APPLICATION FOR A NON MATERIAL AMENDMENT UNDER SECTION 96A OF THE TOWN AND COUNTRY PLANNING ACT (1990) ACT TO REF. 75111/APP/2022/1007 IN CONNECTION TO CONDITIONS 2 AND 10 WITH REGARDS TO:

- **ENERGY CENTRE 2**
- **ENERGY CENTRE 3**
- **CANAL ACCESS RAMP**
- **VISITOR RECEPTION CENTRE 1**

LAND AT BULLS BRIDGE INDUSTRIAL ESTATE, NORTH HYDE GARDENS, HAYES, UB3 4QQ

7 03050 - Roof
1 : 200

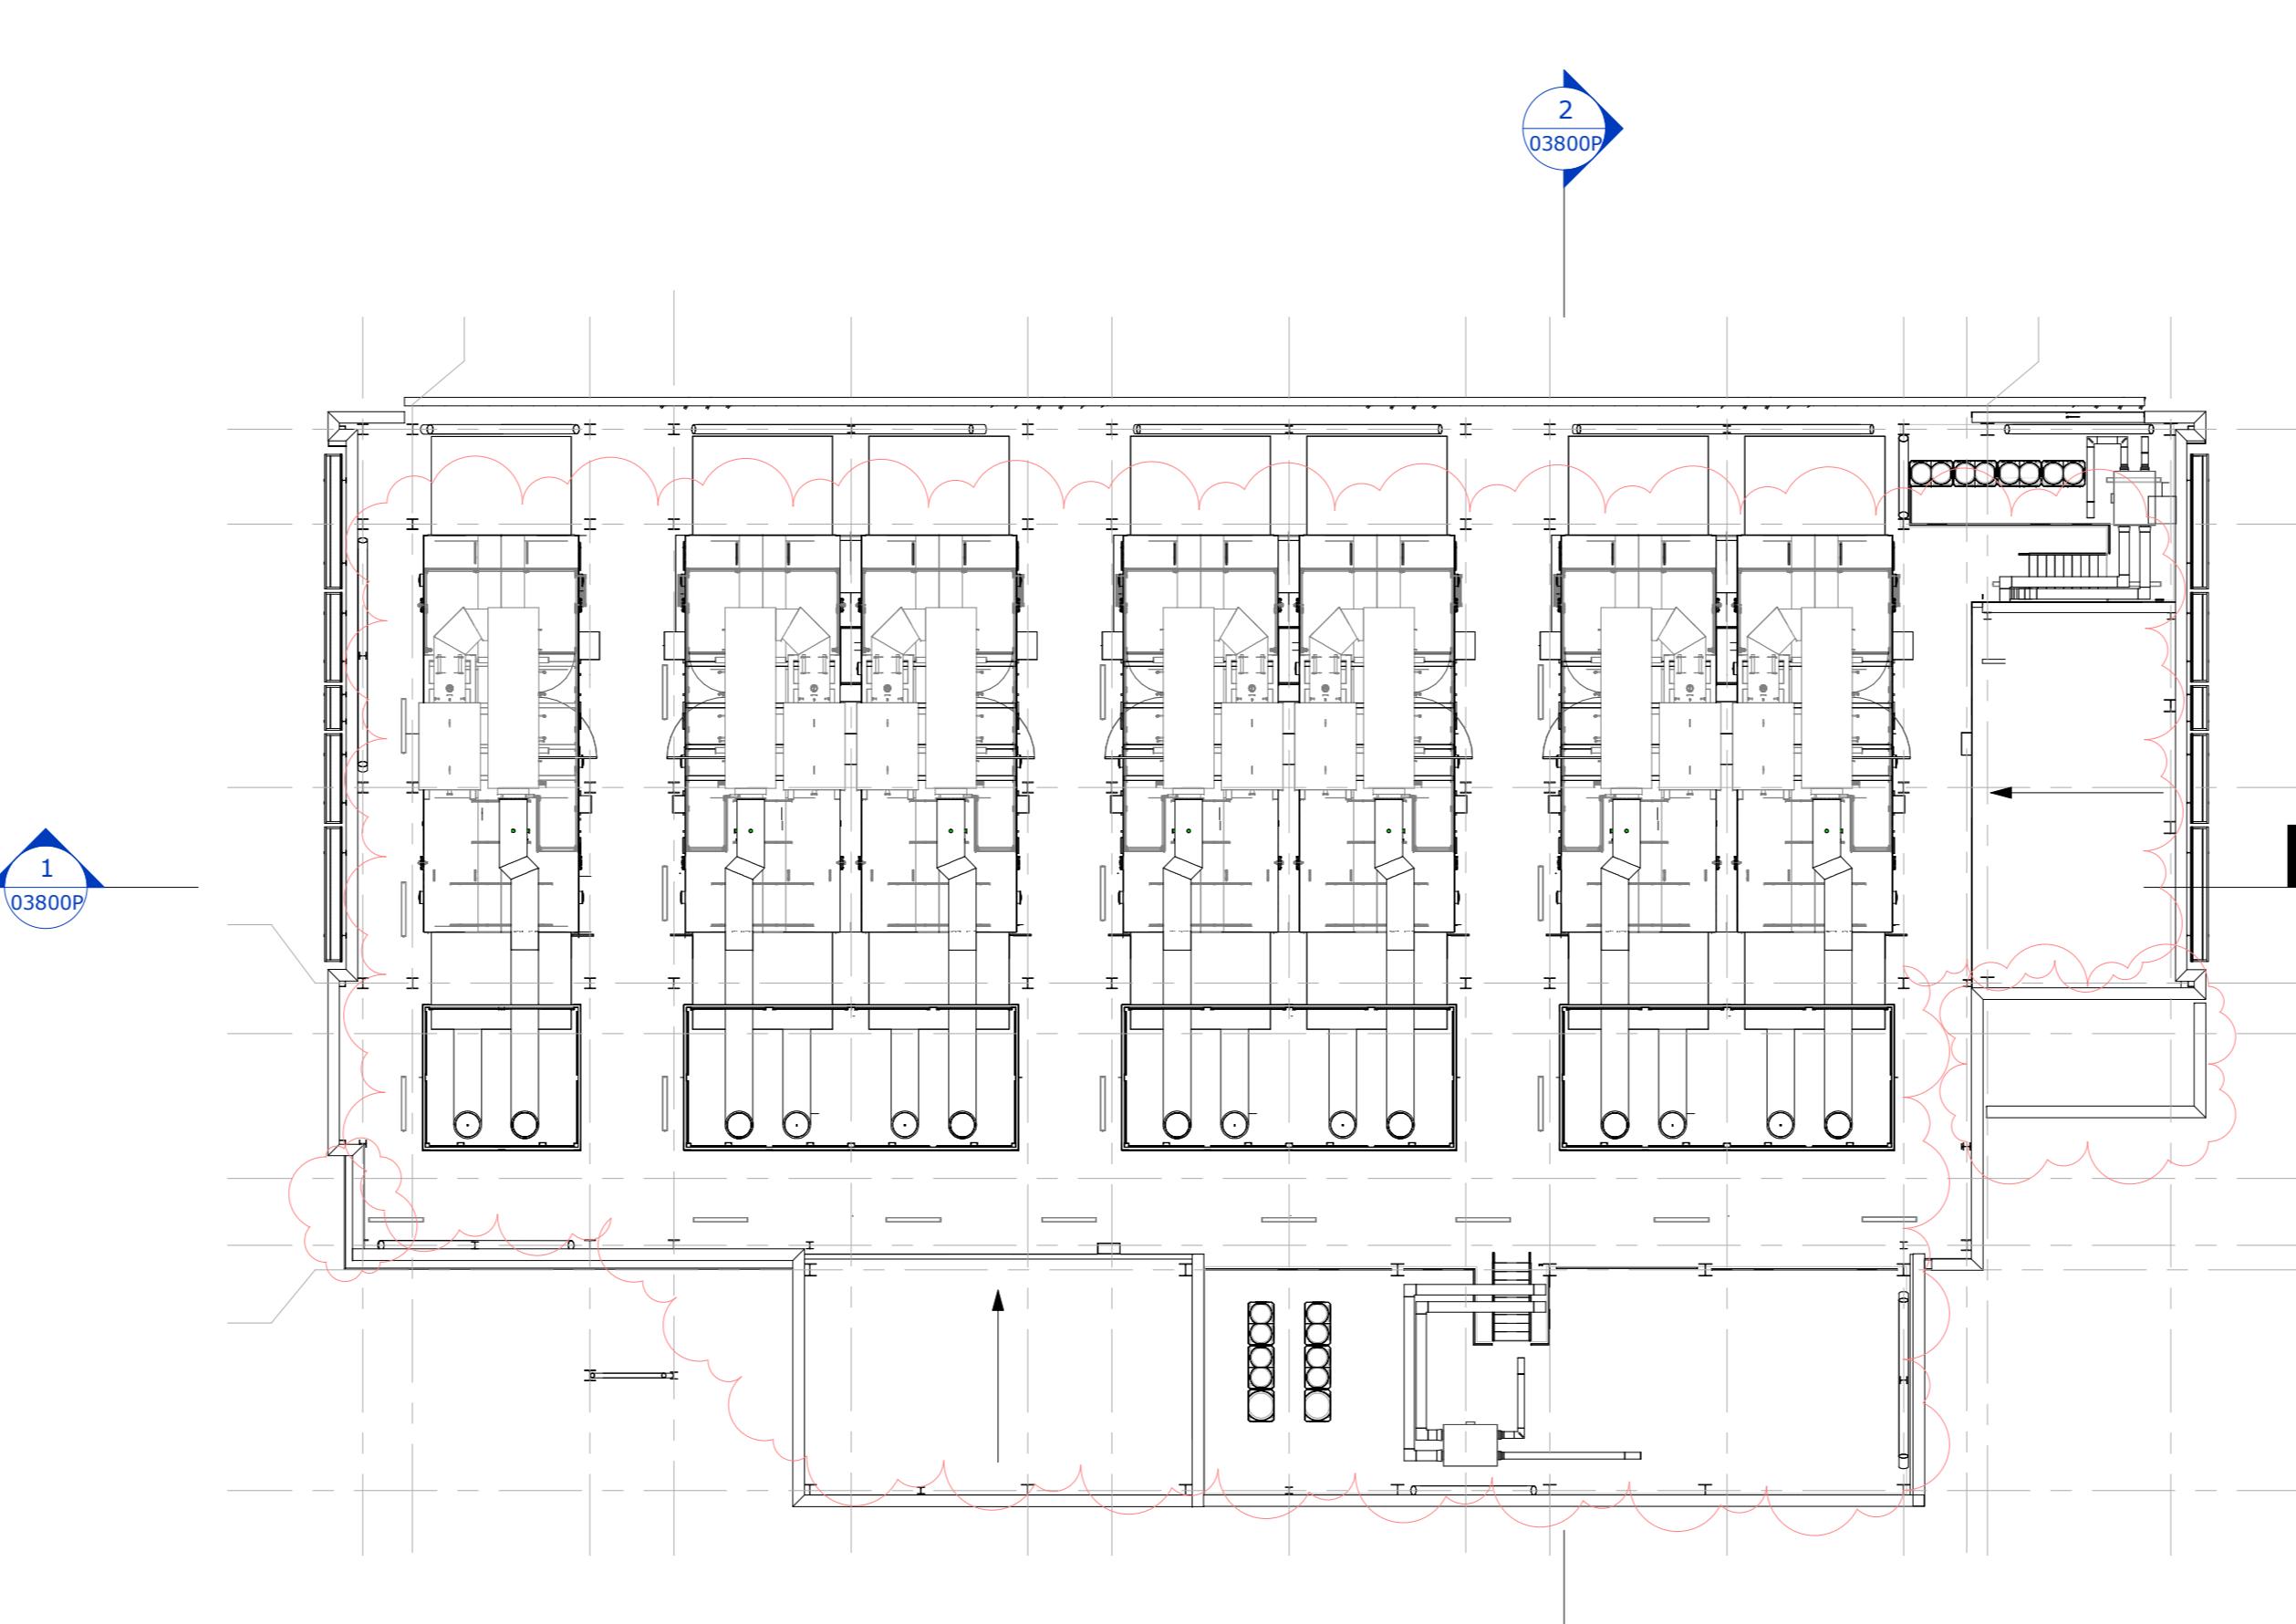
Alteration 1 – Energy Centre 2

The changes proposed to Energy Centre 2 are modest and consist of the following elements:

- Installation of an additional staircase at the southeastern corner of the building. This will be clad in the same materials as the wider building;
- Modest refinement of the footprint of Energy Centre 2 along its western and southern boundary. As shown on the plans submitted, these changes are modest in the extreme and could reasonably be considered to be de minimis;

- To facilitate plant replacement, there is a requirement for the replacement of the brickwork along the northern elevation of Energy Centre 2 with louvres and the replacement of landscaping with planters to facilitate access;

- Reconfiguration of the green wall arrangement along the building's southern and western elevations. Importantly, the quantum of green walling (and the urban greening factor that is achieved) remains unchanged; and

- Reconfiguration of the building's internal arrangement which will mean that the heat rejection stacks will no longer be visible.
